CITY OF ALBUQUERQUE

**Re: Montecito West Units 1 and 2
Grading and Drainage Plan and Drainage Report
Engineer's Stamp Date 1-13-14 (D09/D004)**

Based upon the information provided in your submittal received 1-13-14, the above referenced Grading and Drainage Plan and Drainage Report is approved for preliminary plat approval. The following item has to be addressed prior to grading and work order approval:

**CITY OF ALBUQUERQUE**  
PUBLIC WORKS DEPARTMENT  
MONTECITO WEST UNITS 1 & 2  
GRADING AND DRAINAGE PLAN  
SITE FOR POND 1

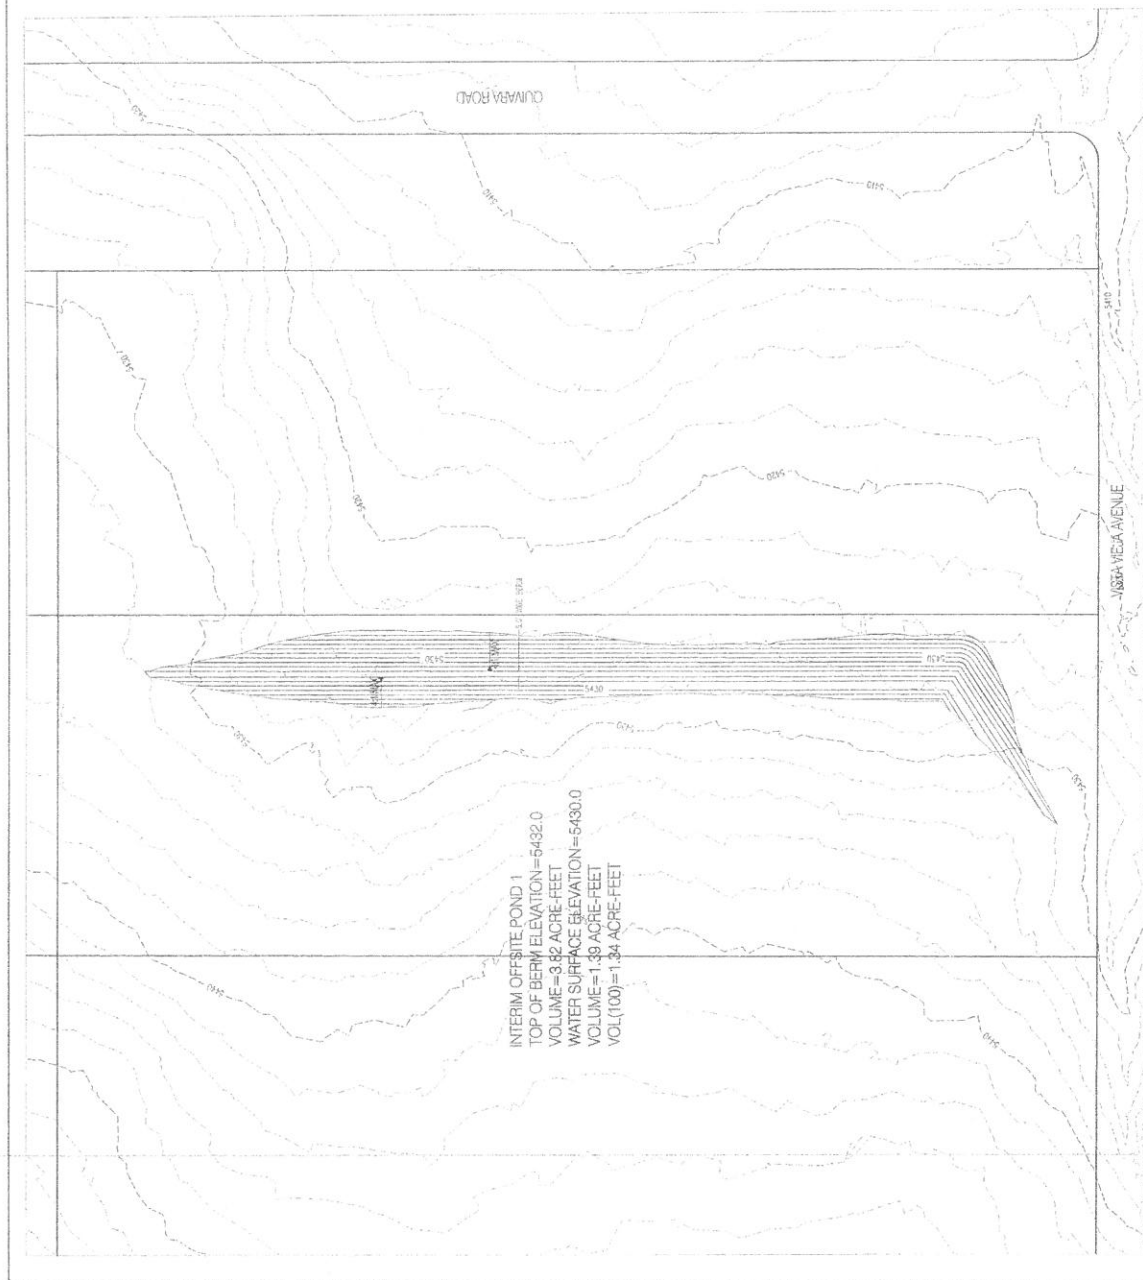
- The controlled discharge measures for the pond (within Tract 1) should be placed in the pond instead of using an orifice plate inside the storm drain manhole.
